Part 3A Revised Concept Plan and Project Application for Graythwaite (ref MP – 0149 and MP – 0150)

GRAITHWAITE PART 3A REVISED CONCEPT PLAN AND PROJECT APPLICATION
(Reference MP – 0149 and MP – 0150)

SUBMISSION TO THE NSW DEPARTMENT OF PLANNING

Level 3 overlay showing
 increased setbacks - SK 100

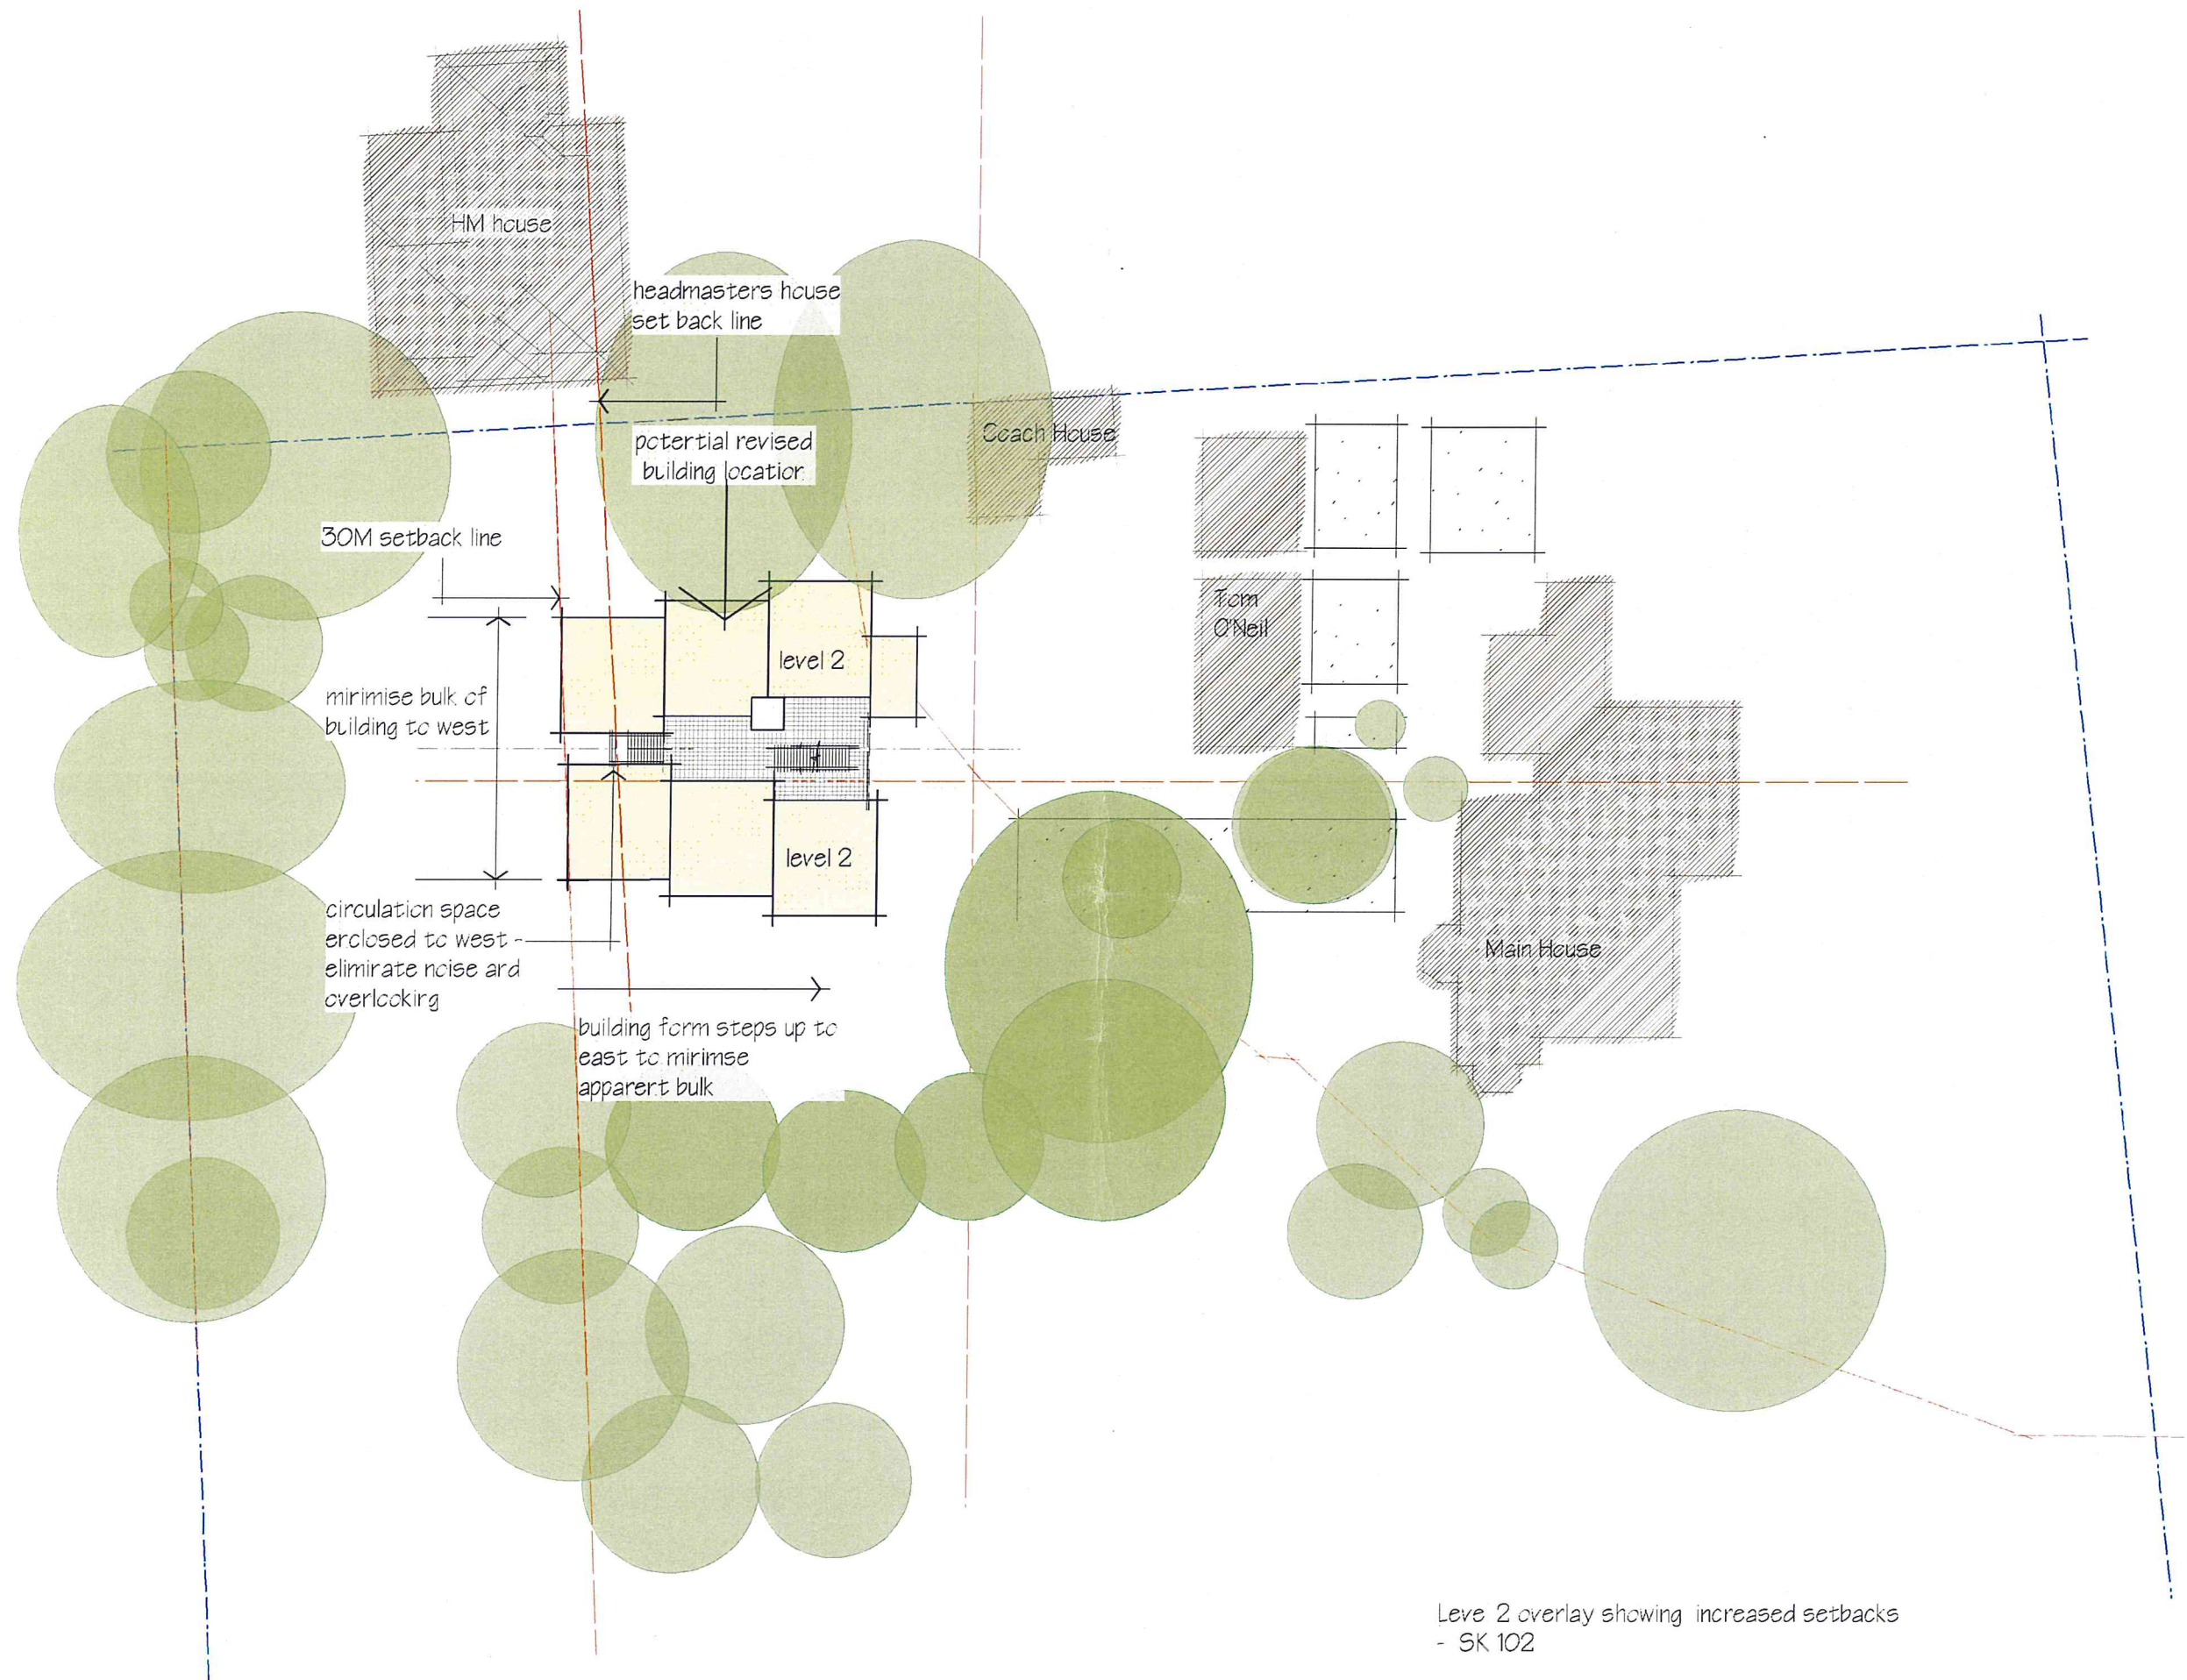
6. There has been a MINIMAL INCREASE IN THE SETBACK of the West Building from the west boundary to the adjoining residences. The northern classrooms have been setback further by only 4 metres, although this part of the building has an additional 'step' that helps reduce its visual dominance. The southern classrooms have been setback further from the boundary, but step more dramatically in a two storey increment, which fails to mitigate the visual impact. In contrast, the residents alternative proposal rejected by the School, would have resulted in a much more meaningful setback.
7. There has been a MINIMAL DECREASE in the amount of additional floor space; a decrease of approximately 400 square metres (from 5,345 square metres to 4,945 square metres), or less than 8%.
